From: Claire Potts
Sent: 14 June 2017 13:11
To: Planning.Responses
Subject: BE/65/17/EIS

Subject: *OVERDUE* Consultation responses on West Bersted

I am currently finalising ADC's response on the Scoping Request for West Bersted BE/65/17/EIS. The deadline for issuing the Opinion is this Friday 16th and this is not moveable so I need to finalise the draft tomorrow (Wed). Therefore please could I have comments by the end of tomorrow.

Client Church Commissioners for England &
Landlink Estates
project West Bersted
Bognor Regis
drawing title PHOTOVIEWPOINT LOCATION PLAN

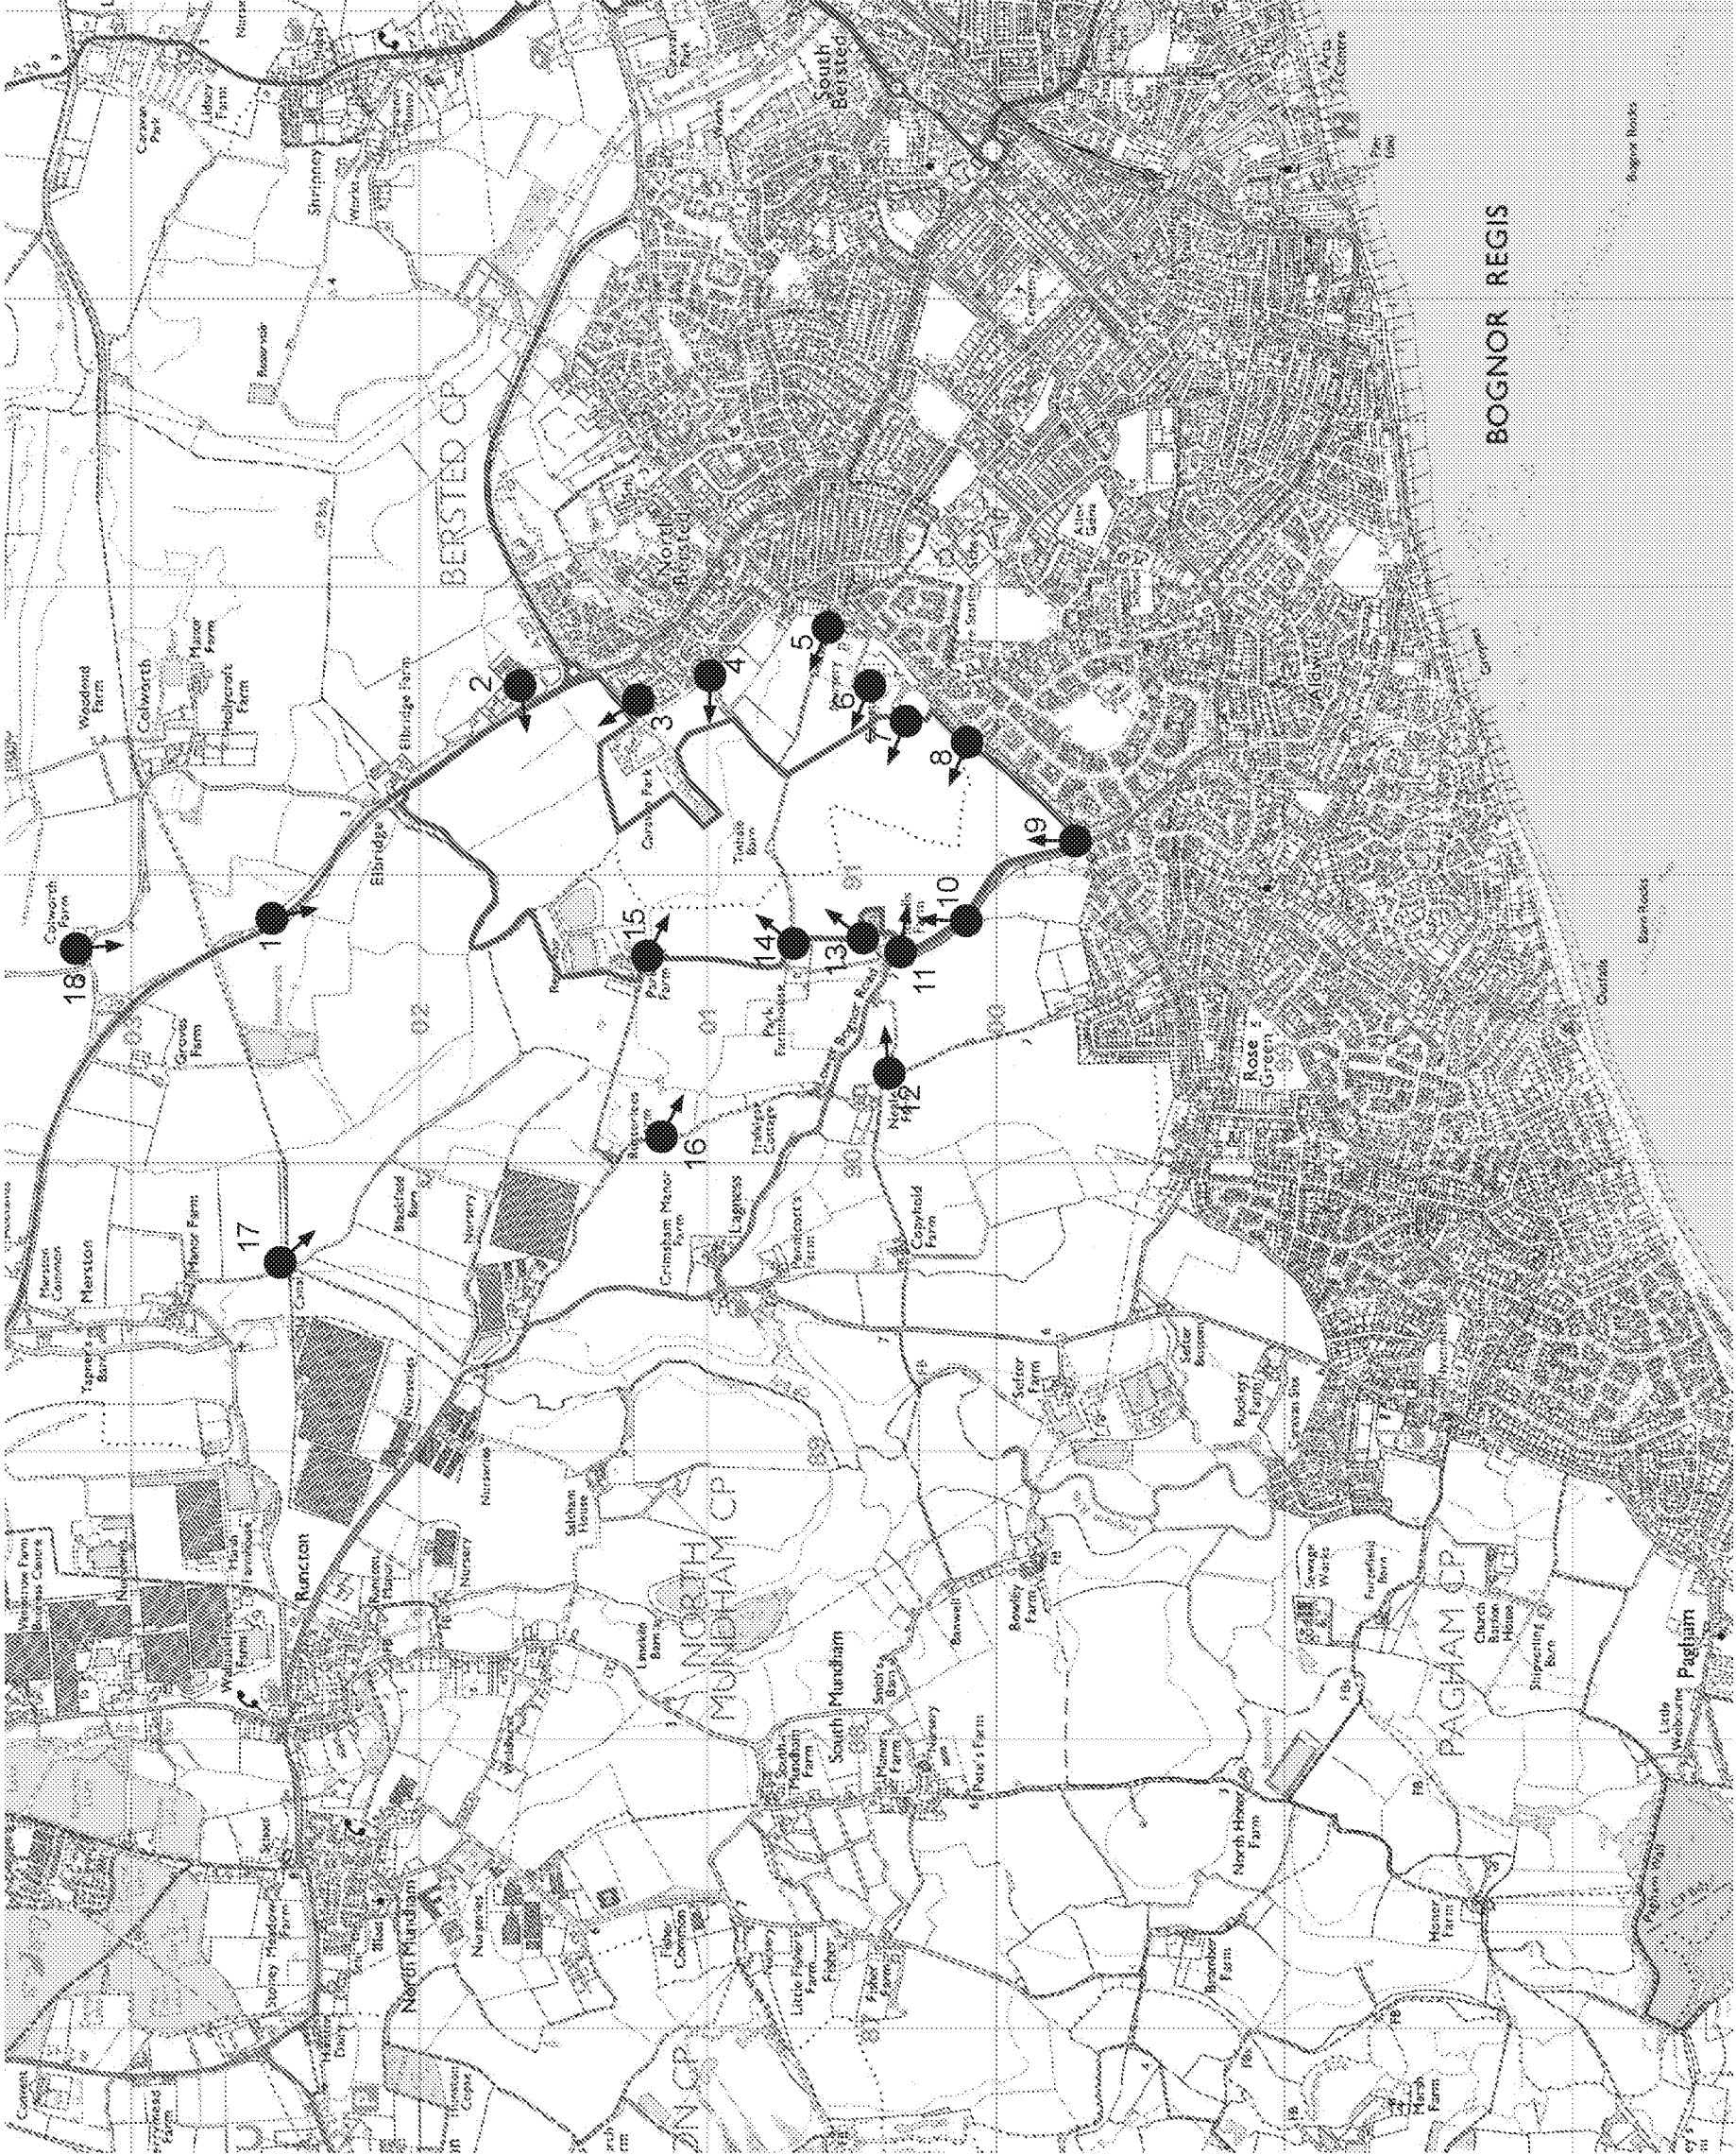
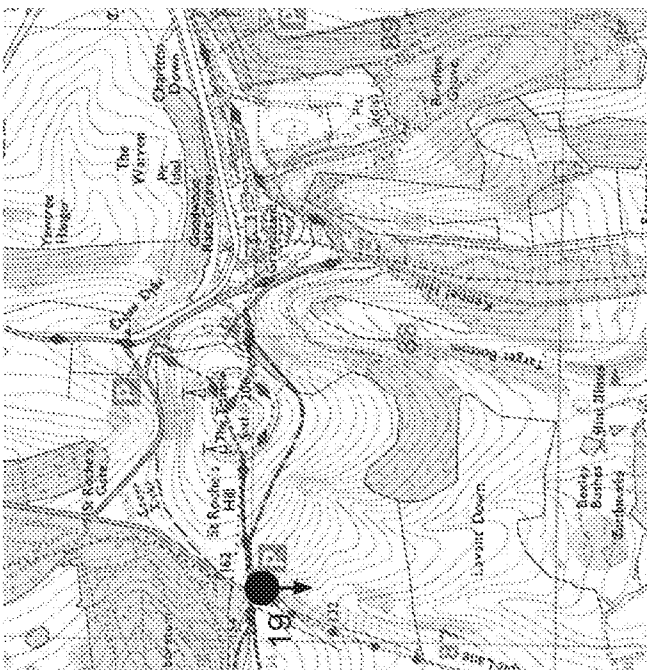
Ok I have had a look at the viewpoints indicated which generally look fine and what we would expect to see. My only observation would be that viewpoint 19 (The Trundle, South Downs) appears to be the only distant viewpoint, there may be benefit and potential to have further extended viewpoints from the North and West towards the proposed development?
